Arun District Council
Arun Civic Centre
Maltravers Road
Littlehampton
West Sussex BN17 5LF
Planning & Building Control General Enquiries
Tel: (01903) 737756 Fax: (01903) 730442
Dx: 57406 Littlehampton
Minicom: 01903 732765
e-mail: planning@arun.gov.uk
website: www.arun.gov.uk/planning

Application No: FG/196/21/HH
Site Address: 9 Telgarth Road Ferring BN12 5PX
Description of works: Erection of single storey side infill and rear extension, hip to gable roof extension to include 2 x side dormers, installation of front porch canopy and alterations to fenestration/openings.

Thank you for your internet representation made on 21st December 2021 which has been recorded as support with the comments as follows:

Obscure Glazed Non
Opening Below 1700mm

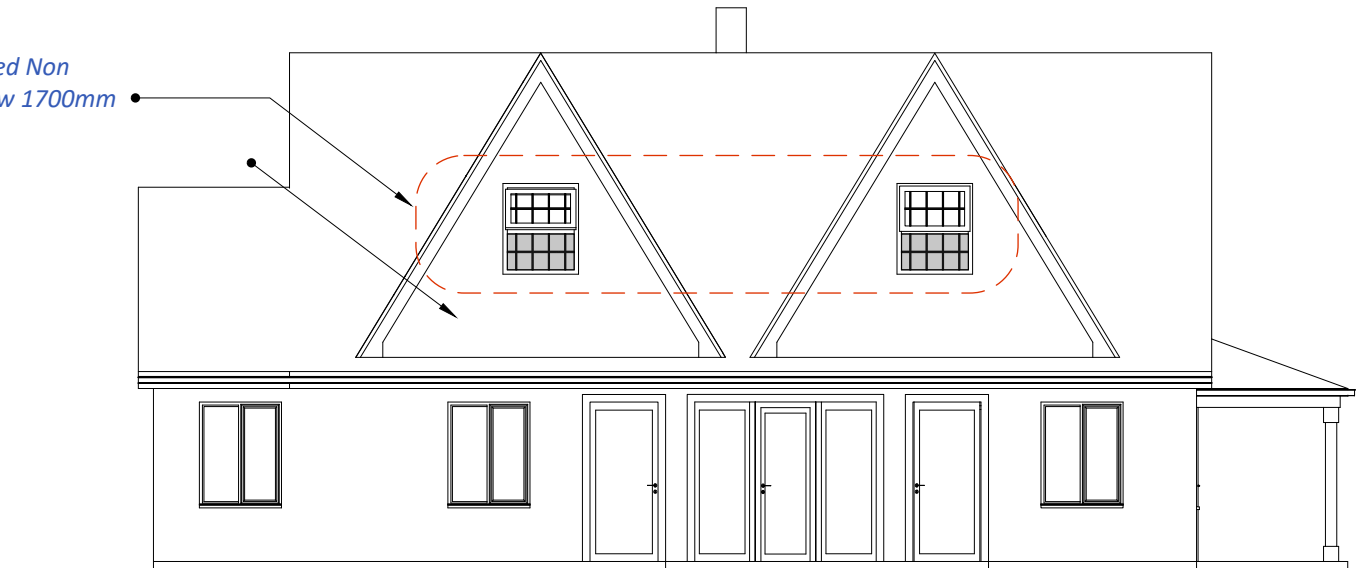
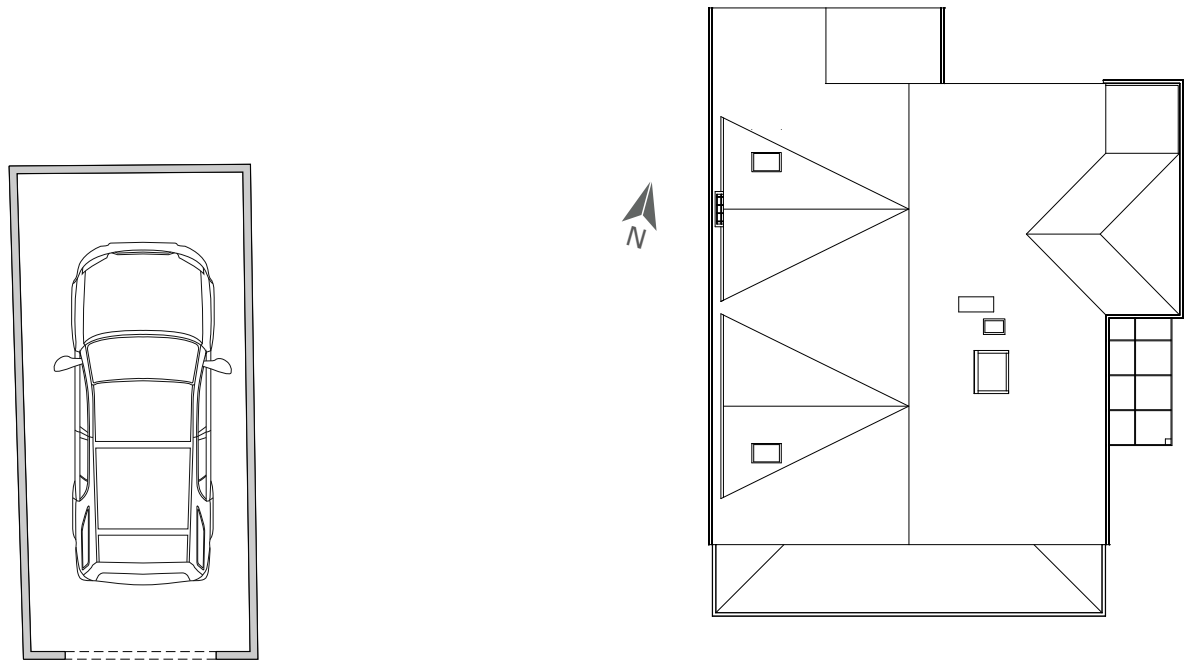
I have viewed the plans for this substantial roof extension, which are basically as previously rejected on appeal, apart from the gable windows now being in obscure glass.

I remain convinced that ANY opening gable window overlooking my property, however glazed, will present an unacceptable invasion of my privacy, and would urge rejection of this application accordingly.

A 04

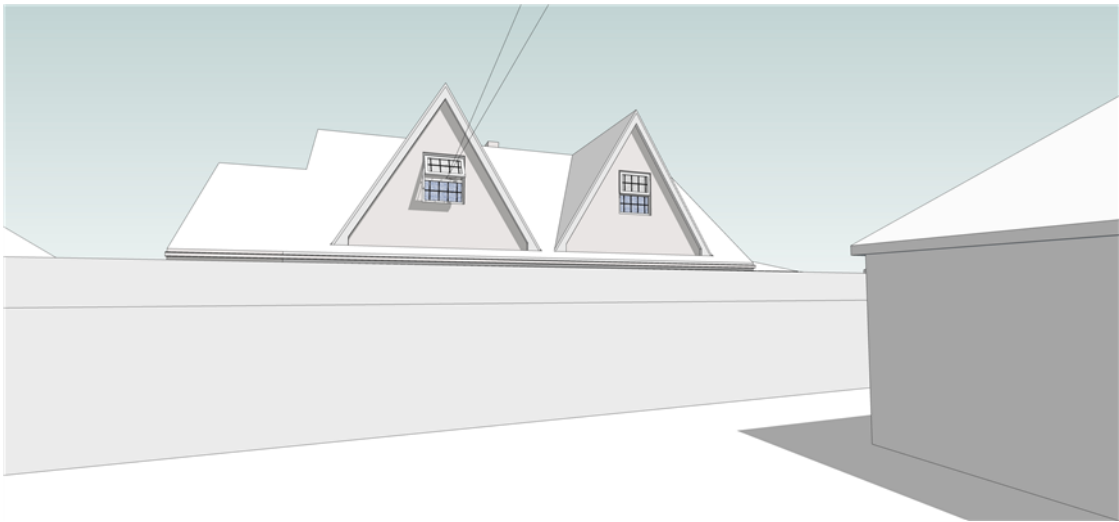
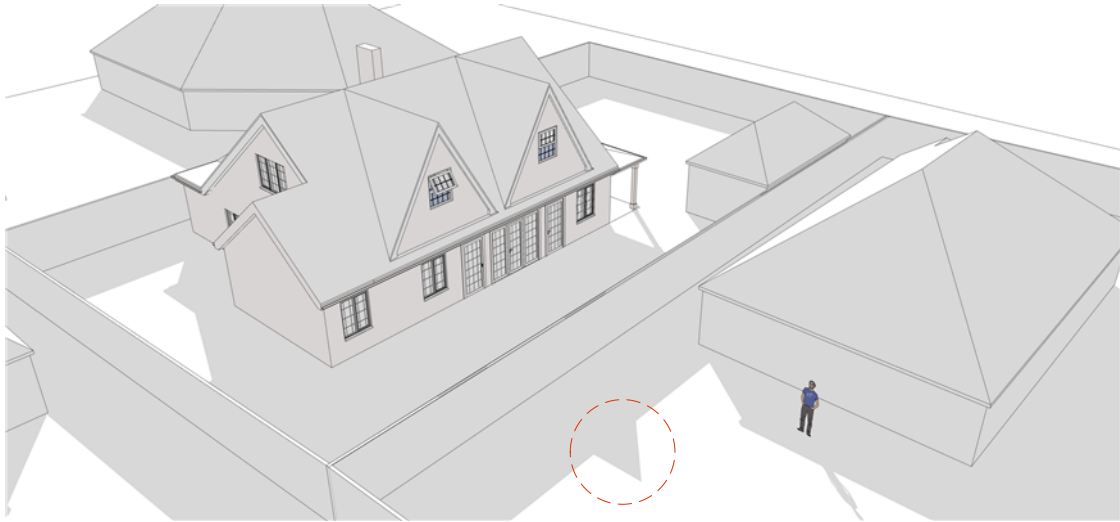
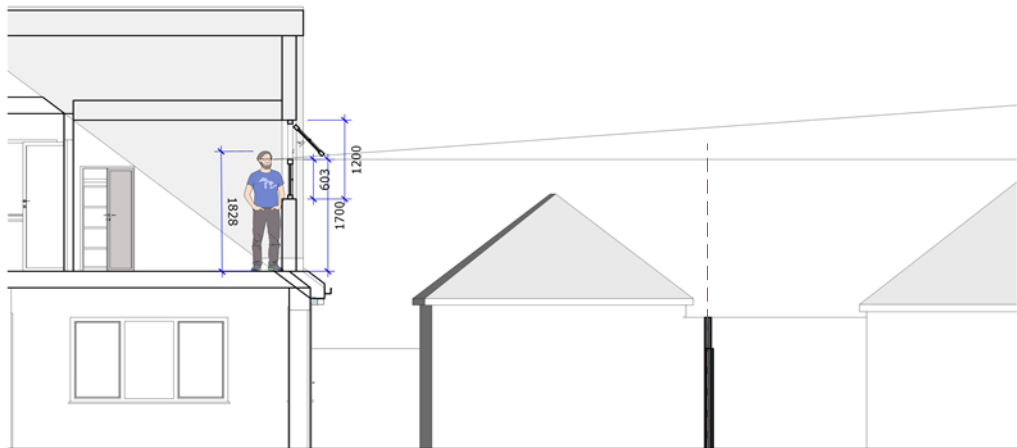
Whilst it is emphasised on sheet A4 that using the applicants floor to window opening of 1700mm, and person height of 1828mm, the field of view is restricted, clearly any small variation to these figures would significantly affect the sightline.

For clarity, the garage is not between the two properties, and has no bearing on the field of view.
